From: Stuart Corbey
Sent: 01 October 2018 09:56
To: Planning.Responses
Subject: FW: EP/120/18/PL - The Loft 131A Sea Road - Change of use of boat store & sail loft (Sui Generis) to 1 No. dwelling (C3 Dwelling house).

Subject: EP/120/18/PL - The Loft 131A Sea Road - Change of use of boat store & sail loft (Sui Generis) to 1 No. dwelling (C3 Dwelling house).

131 Sea Road, East Preston, Littlehampton, BN16 1PD

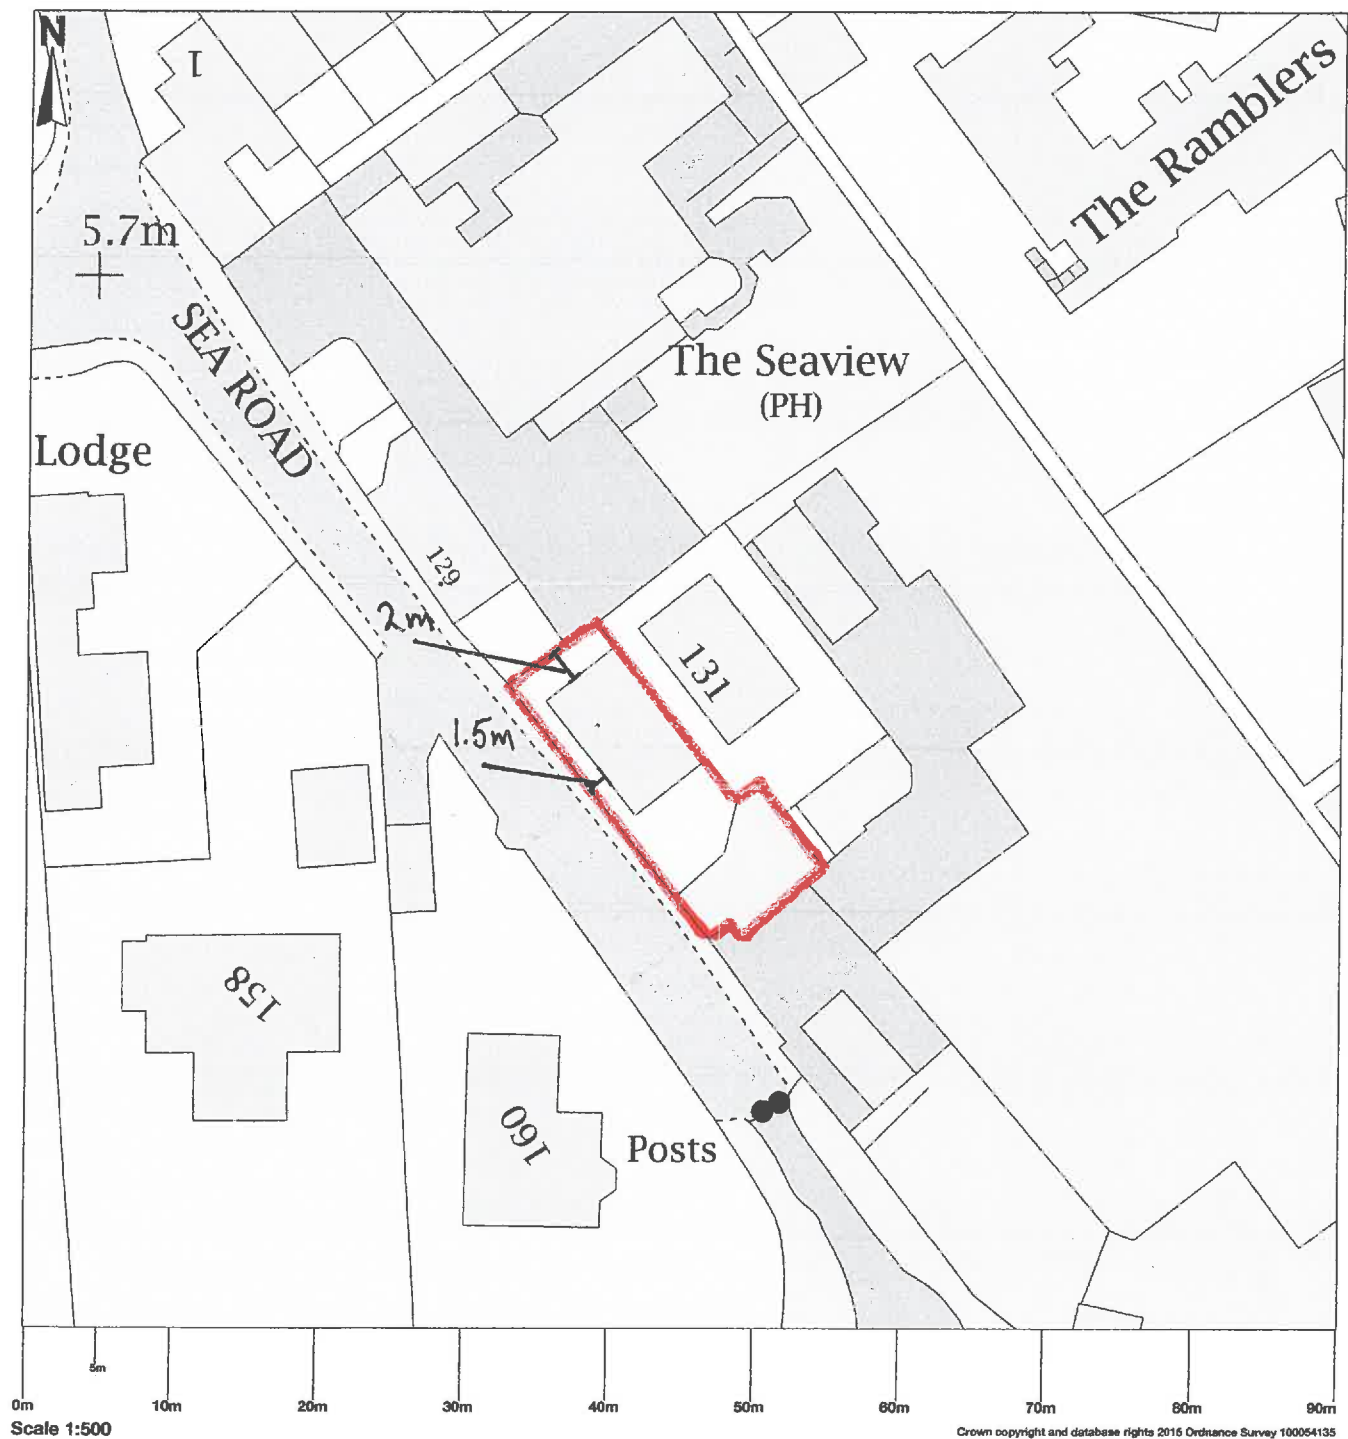
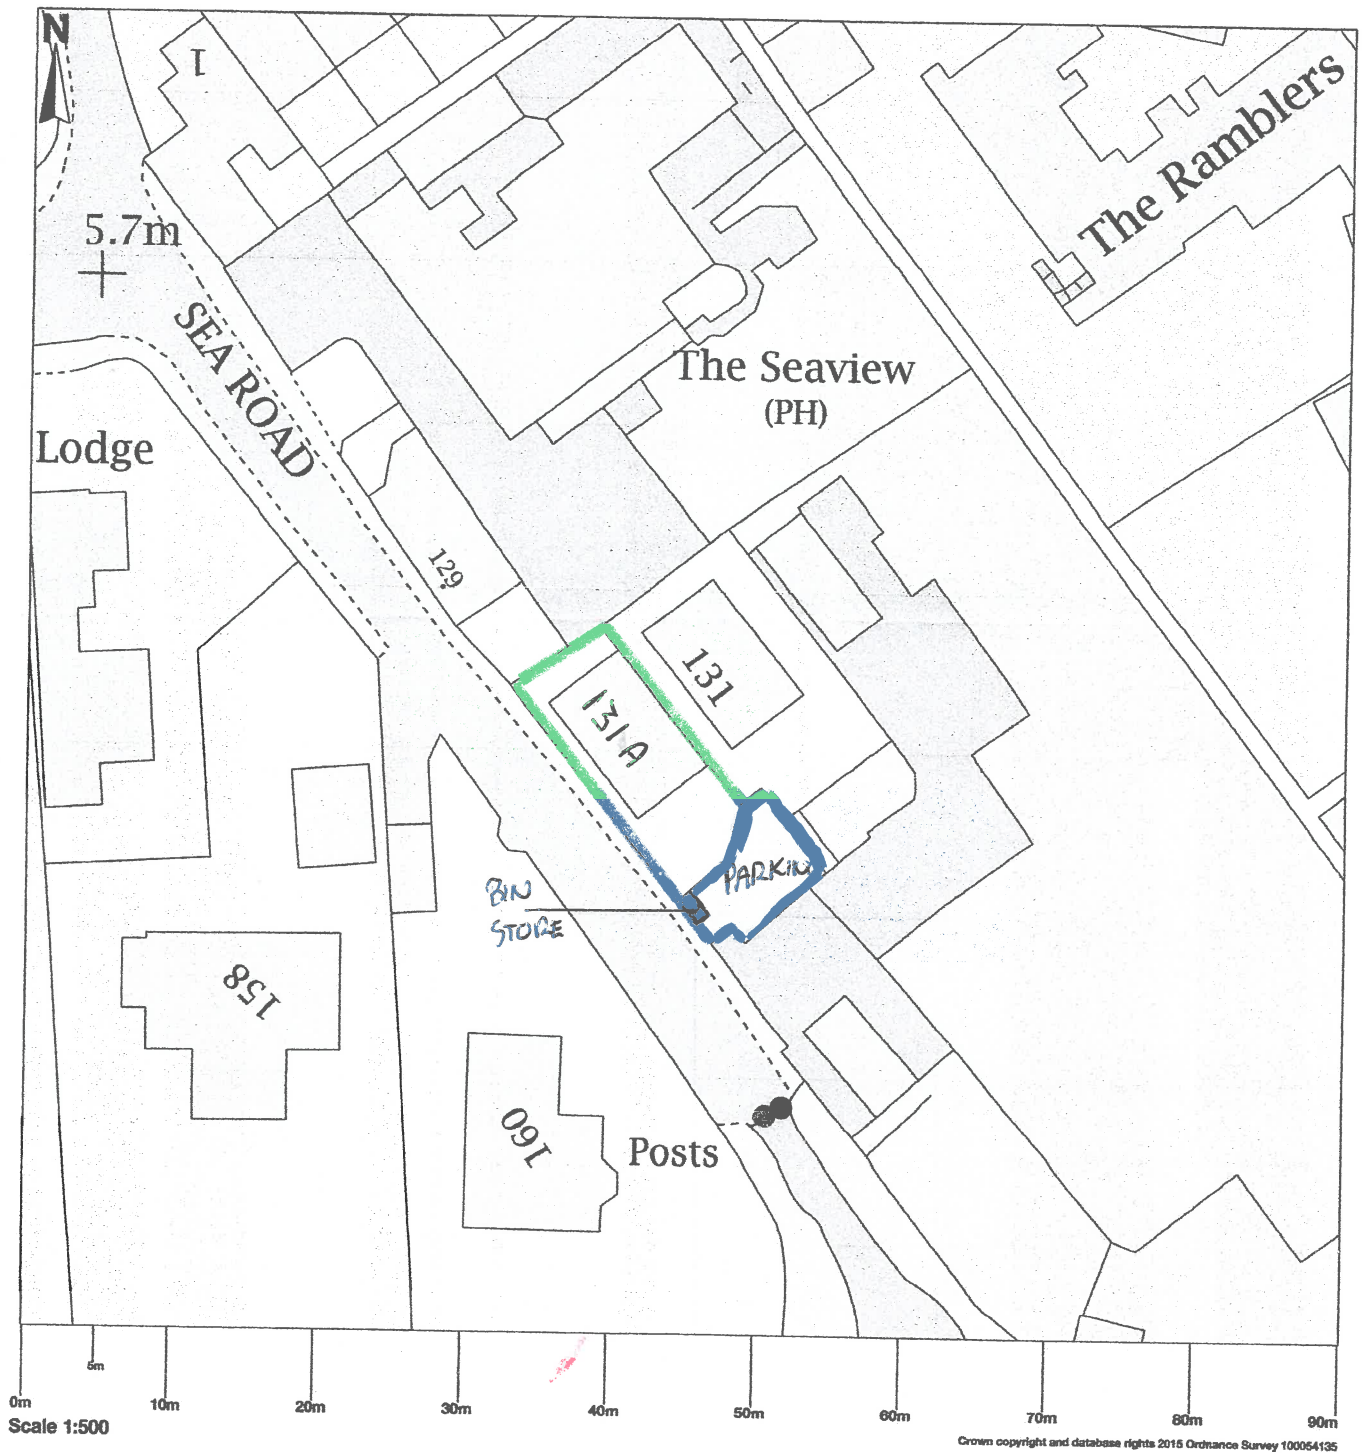
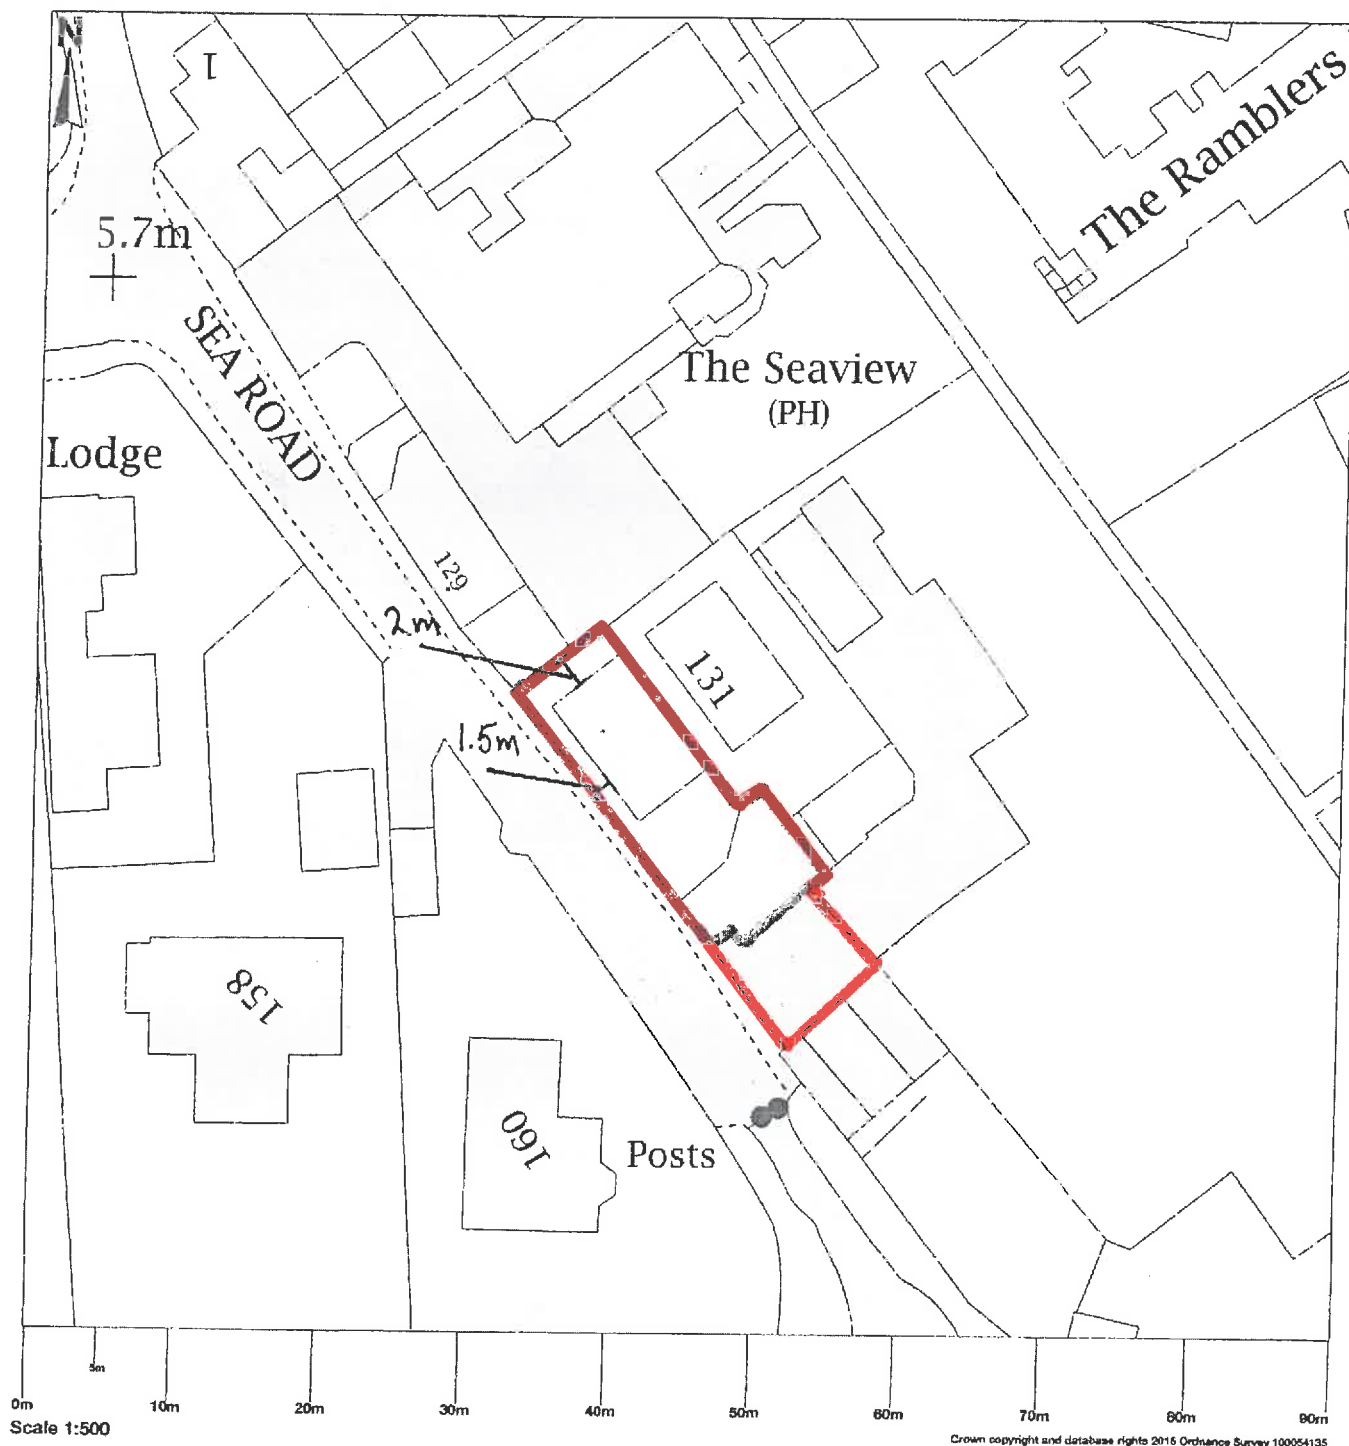
In regard to the parking arrangement. From conducting a site visit it would appear the access to the parking space is via a gate which could be outside the occupants control. Could you confirm the position as the red line should include a means of access to the public highway, and a certificate B seeking permission from land owners of the access (if not in the ownership of applicant) should be sort.

- Revised Site Location Plan – red edge now showing access and remaining land under the applicants ownership
- Revised Block Plan
- Existing and Proposed Ground Floor Plan – labelling rooms
- Existing and Proposed First Floor Plan – labelling rooms

EXISTING + PROPOSED
FIRST FLOOR PLAN

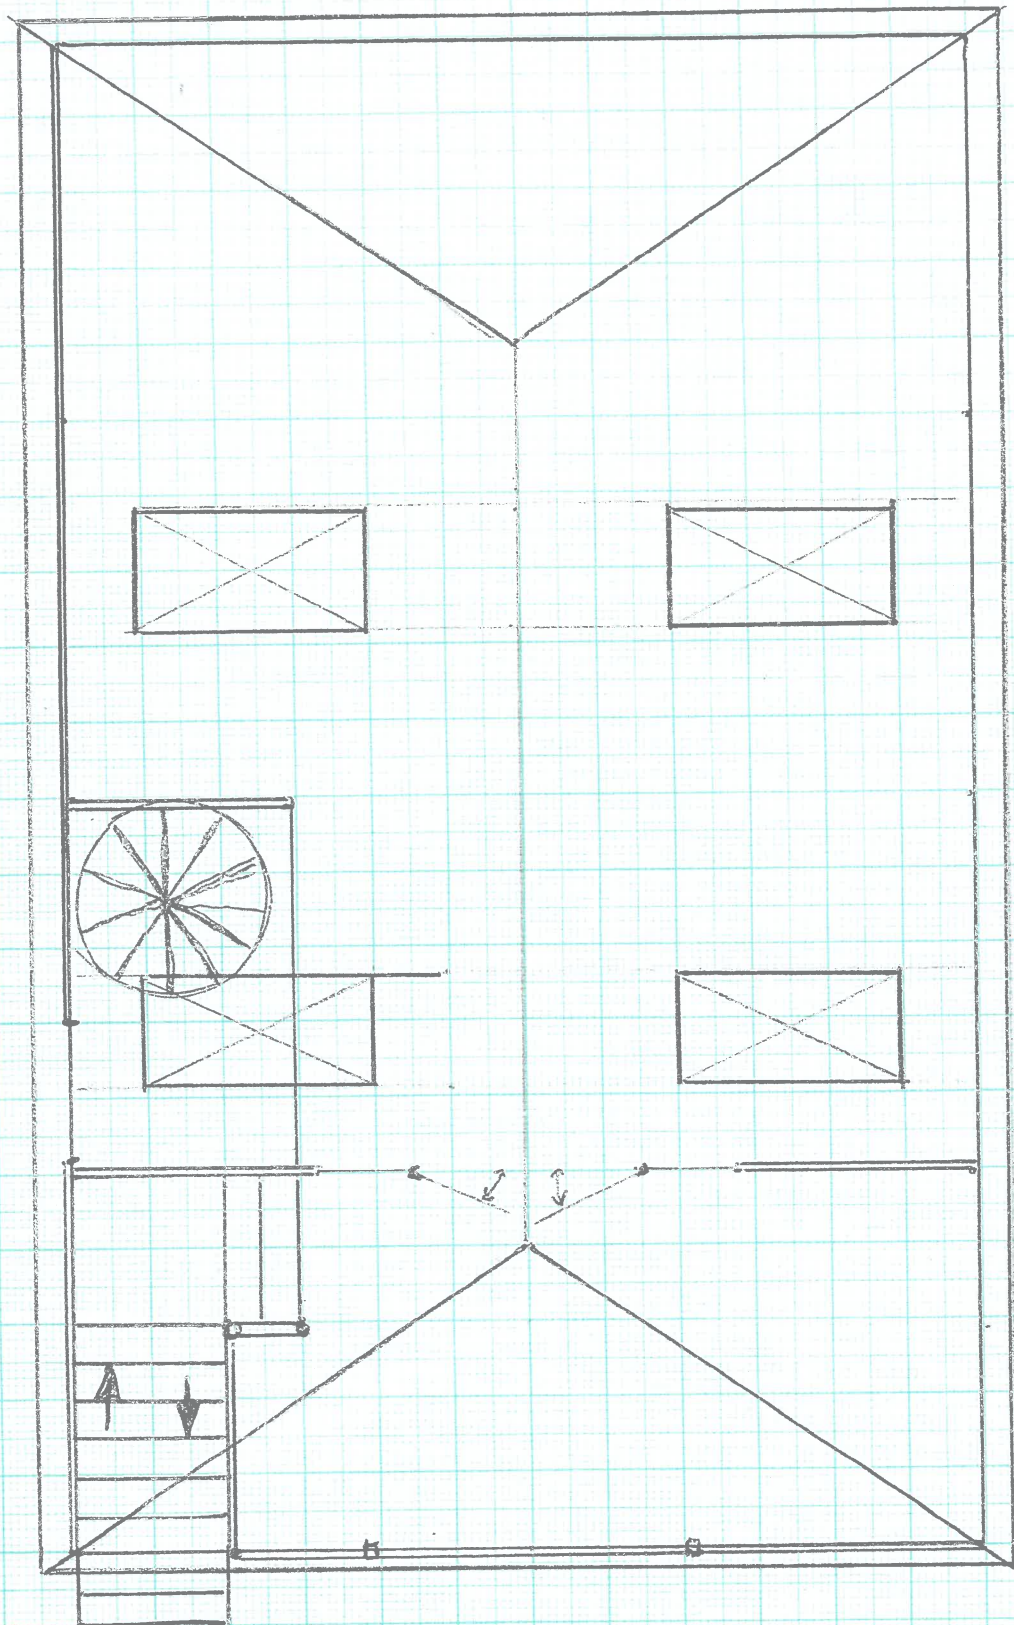
Would you be able to provide a clear ground and first floor layout plan with the rooms listed to assist with our assessment.
